**WELWYN HATFIELD BOROUGH COUNCIL
EXECUTIVE DIRECTOR - PLANNING, PUBLIC PROTECTION AND GOVERNANCE**

DELEGATED APPLICATION

Application No: 6/2022/1834/HOUSE
Location: 81 Eddington Crescent Welwyn Garden City AL7 4SX
Proposal: Erection of single storey rear extension and loft conversion including the insertion of four rooflights.
Officer: Mr Raymond Lee

Recommendation: Granted

DWG NO: 81 - EC - 102 **ISSUE:** A

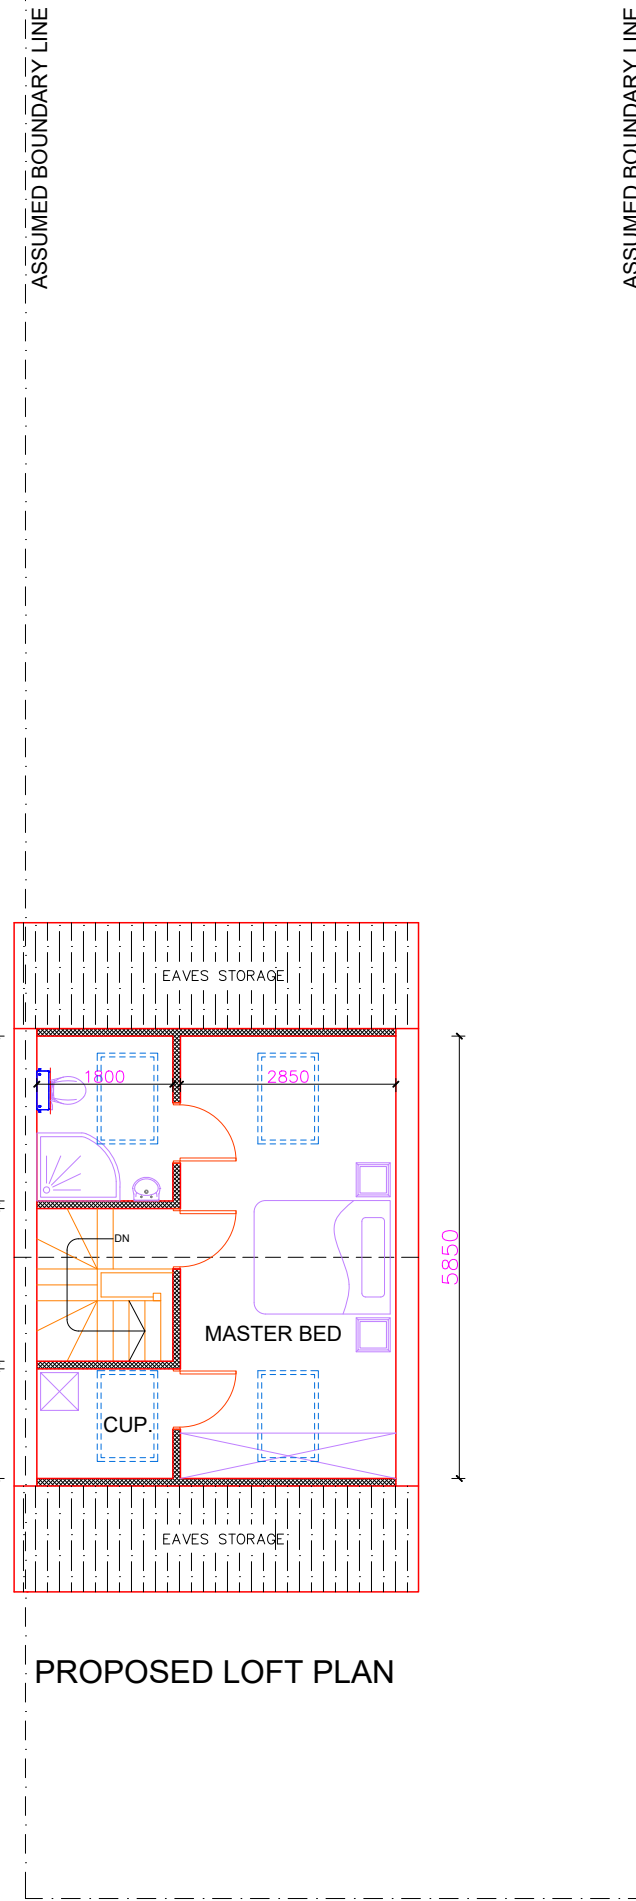
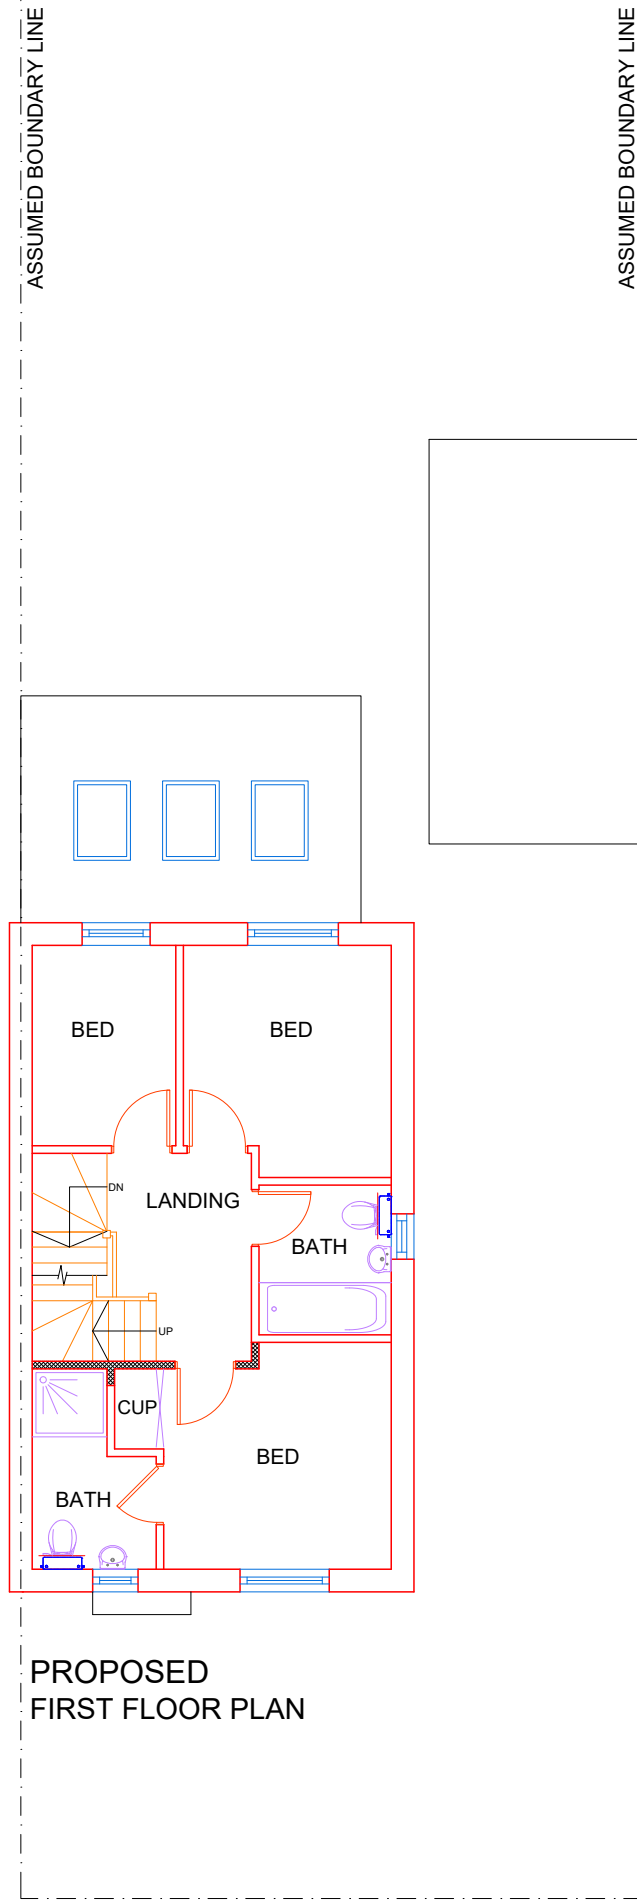
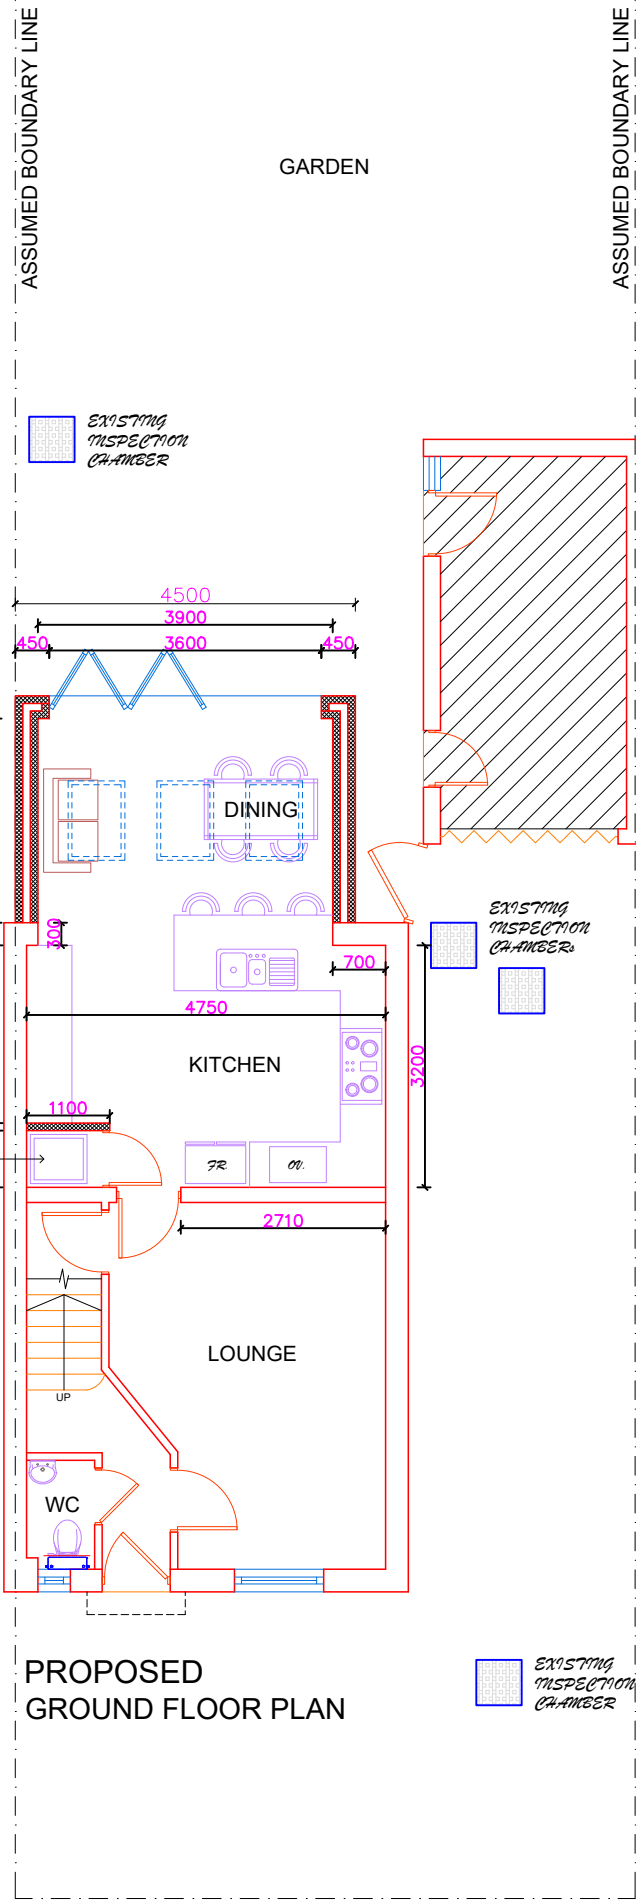
In this case, the proposed rear extension would span almost the whole width of the building. The depth of the extension would however be modest, being less than half that of the host property. The extension would also be single storey in height. As such it is considered that size and scale of the proposal would appear subordinate to the existing dwelling and would not result in a cramped form of development within its site. The proposed mono-pitch roof would not be entirely out of keeping with the host property and the positioning of the extension at the rear of the semi-detached dwelling would effectively conceal the development from views of the street scene. The materials are also proposed to match the existing building which can be reasonably secured via condition.

It is considered that the positioning, size and scale of the extension would not result in detrimental loss of light or privacy, nor would the extension appear overbearing or unduly dominant for the adjoining occupants. It is noted that no neighbour objections have been received. Furthermore, the rooflights would not afford any direct overlooking of the neighbours. As such the amenity of the adjoining properties would be maintained to an acceptable level.

**DWG NO:** 81 - EC - 104      **ISSUE**

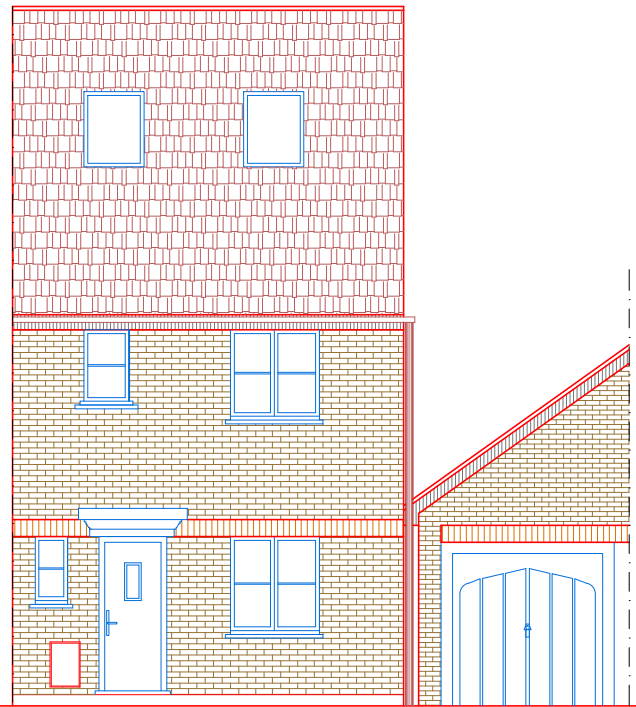
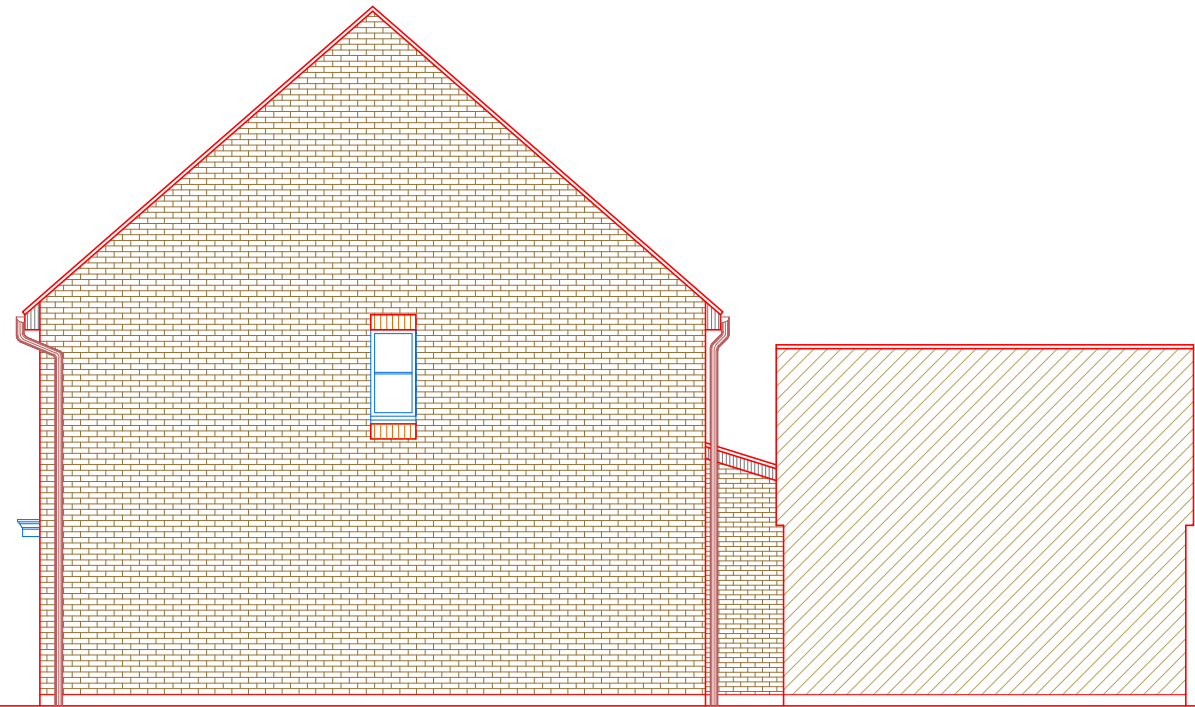
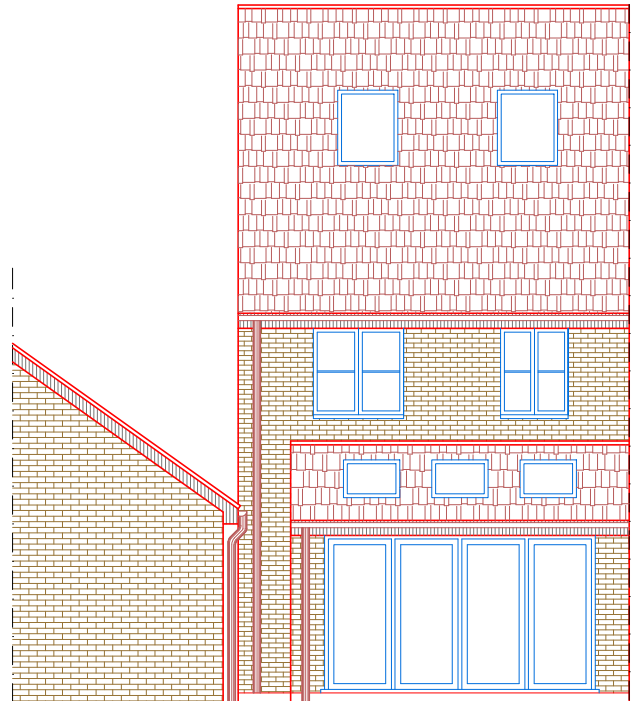
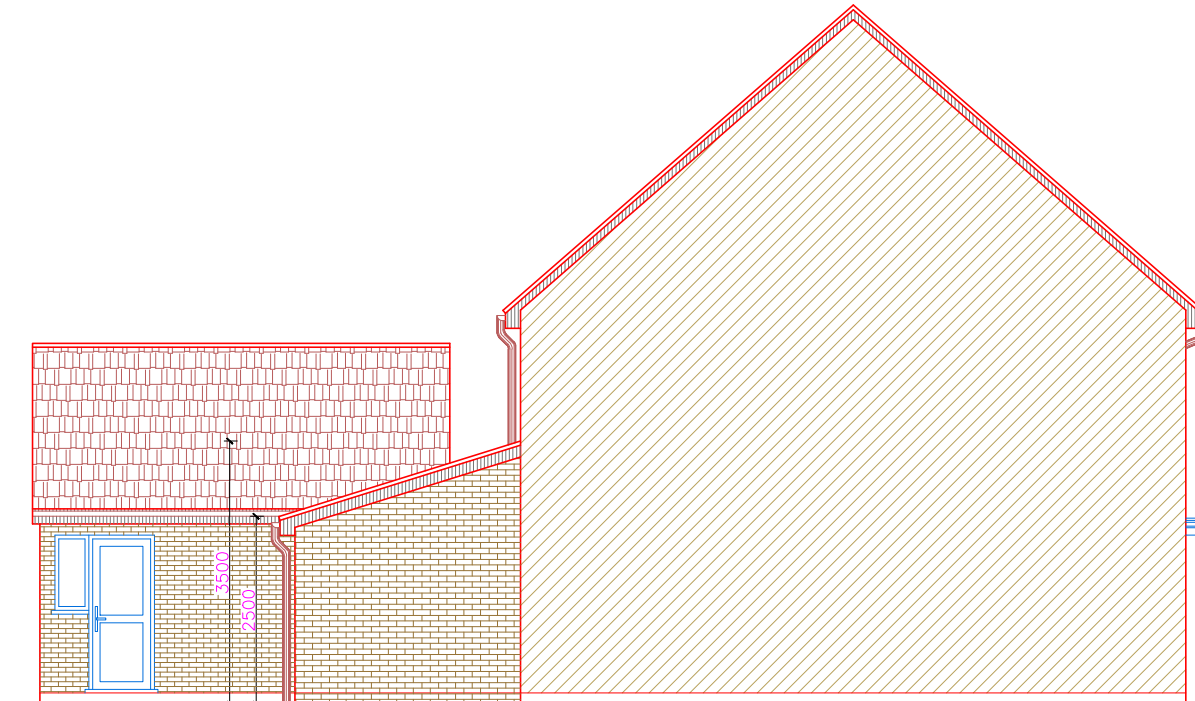
The roof lights proposed to the front and rear elevations are considered a minor alteration and would not form a prominent or incongruous feature of the street scene. Therefore it would have an acceptable impact on the character of the area.
